# CITY OF ALBUQUERQUE

**Re: Albuquerque Winnelson  
3545 Princeton Dr. NE  
30-Day Temporary Certificate of Occupancy- Transportation Development  
Transportation Development Final Inspection  
Architect's Stamp dated 9-26-16 (G16D152)  
Certification dated 12-20-17**

G-002

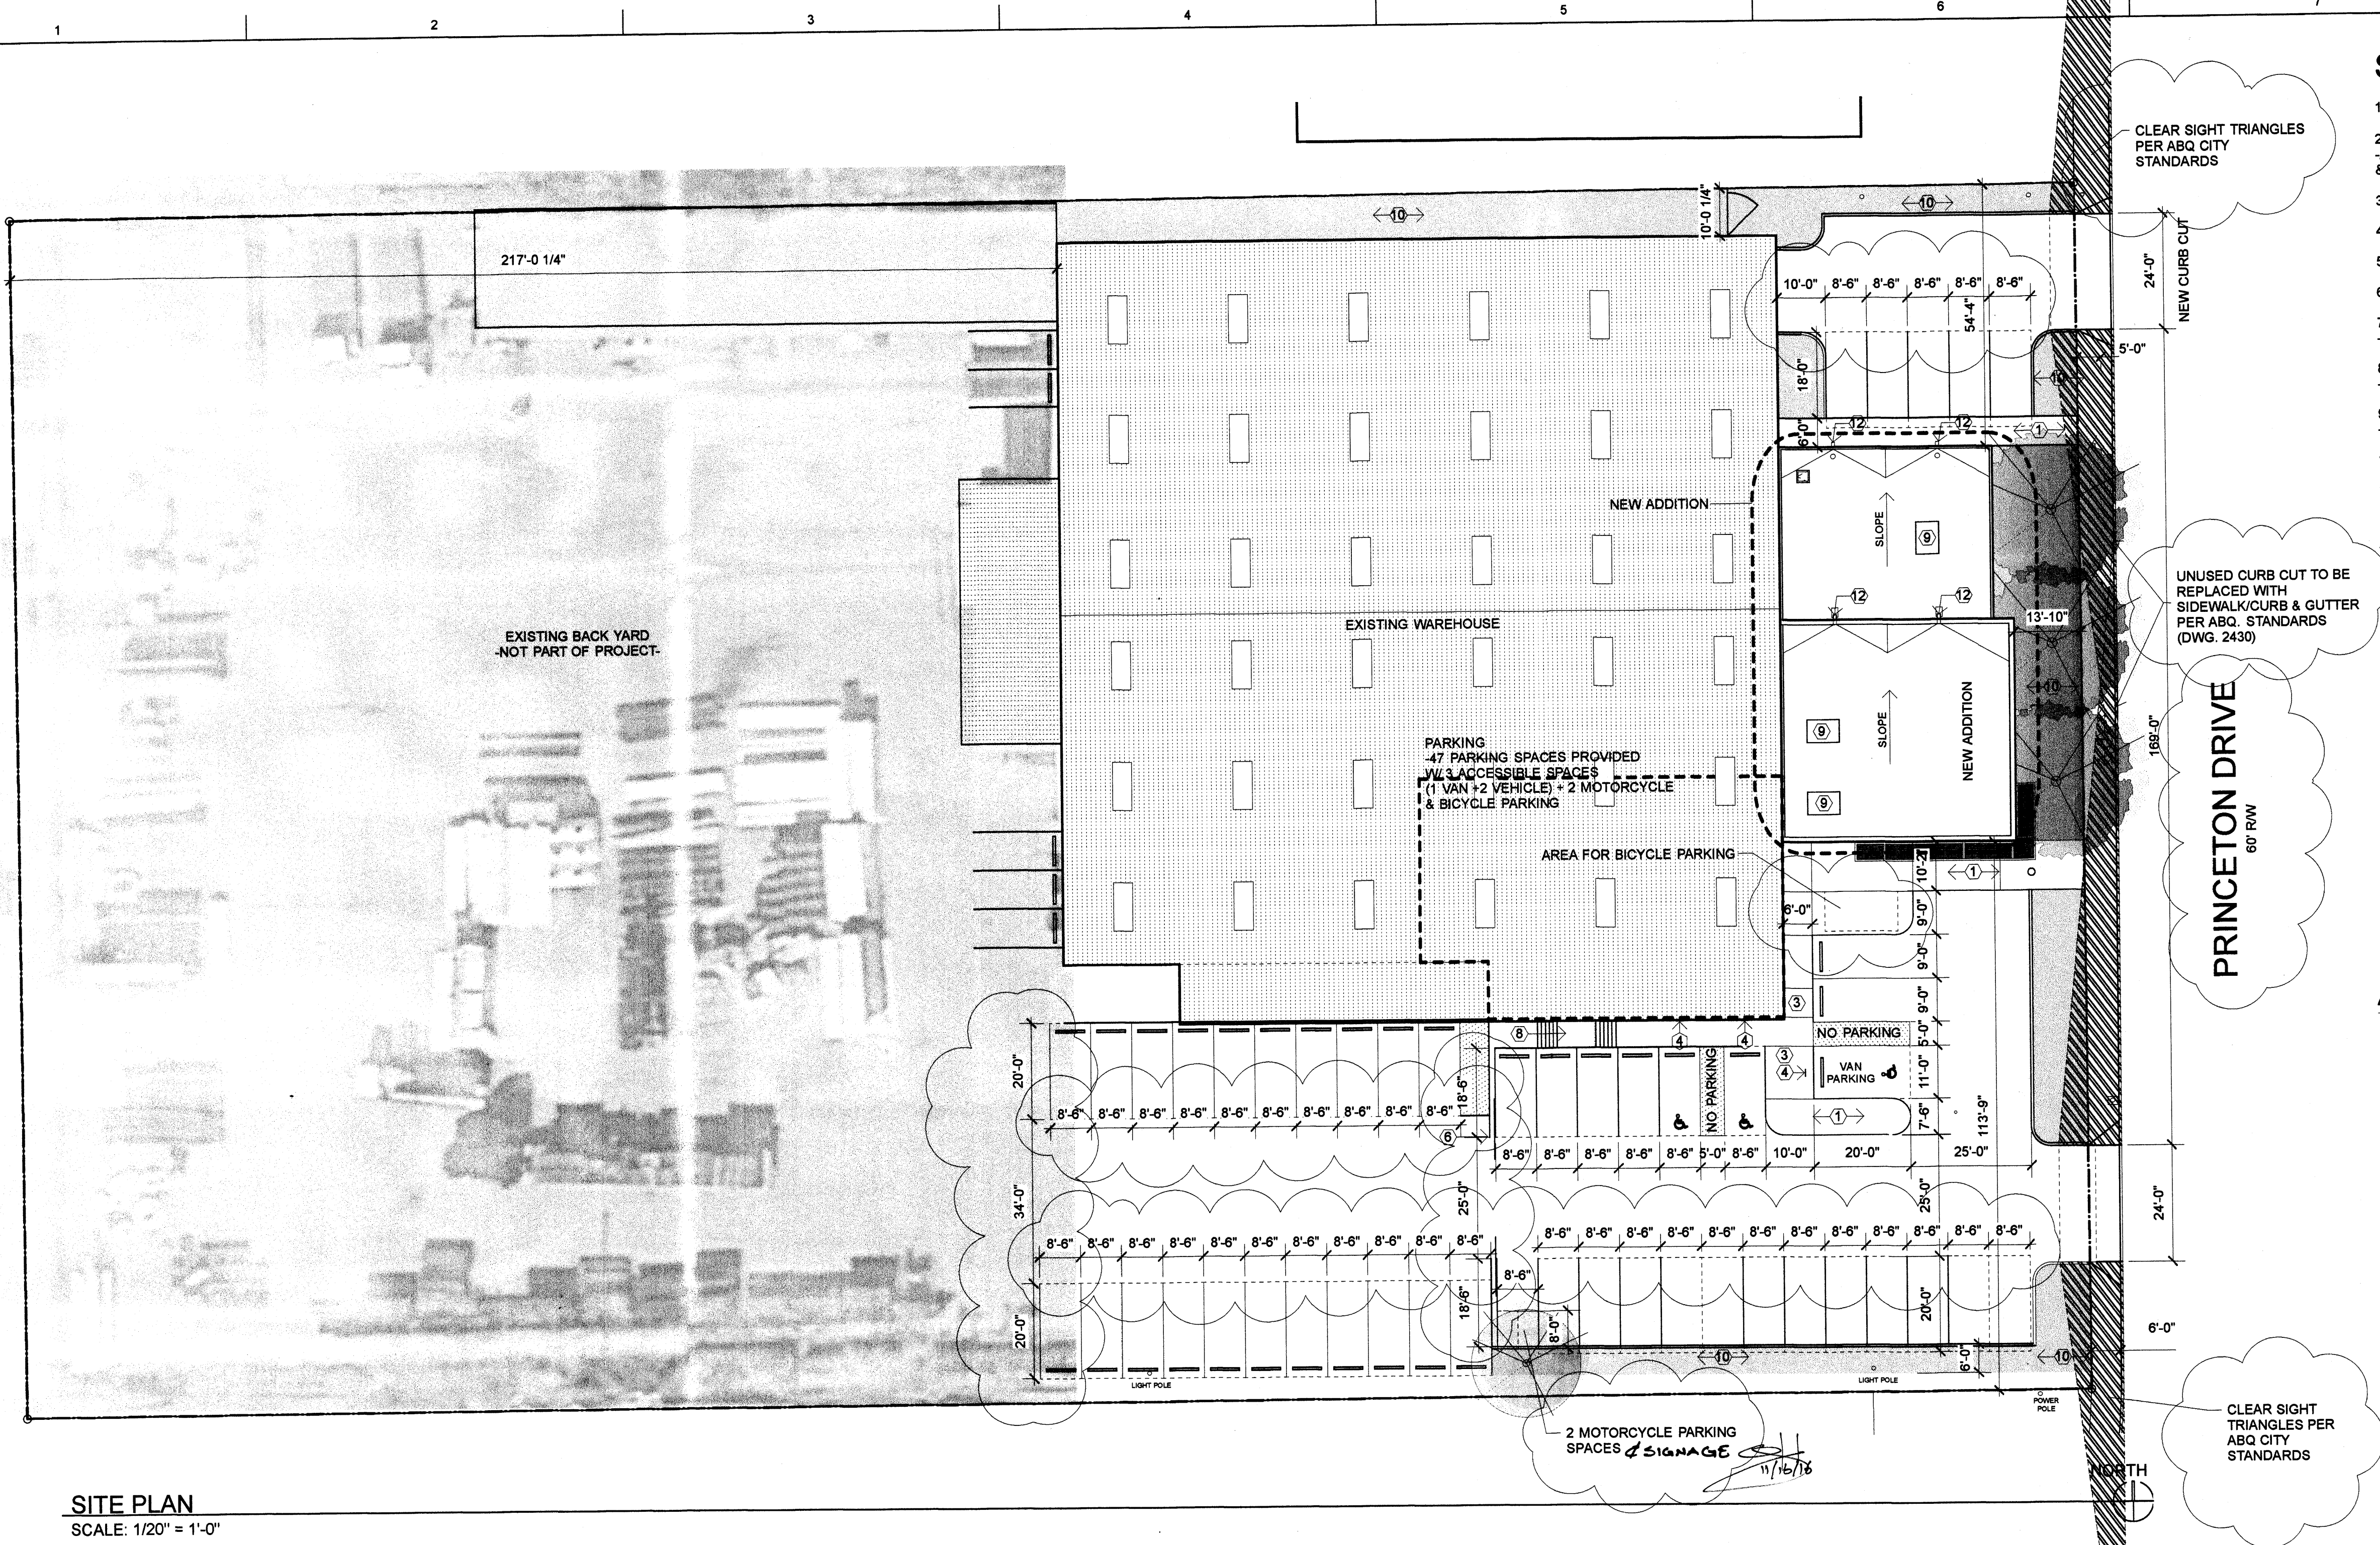
1. Bike rack has not been constructed per the plan.
2. Motorcycle parking sign is required.

- 1) (1) space at the northeast was displaced by a new PNM power pole. The required space was relocated to the southwest parking area.
- 2) (4) spaces south of the front door were moved to alleviate possible vehicular/pedestrian congestion. The required spaces were relocated to the southwest parking area.
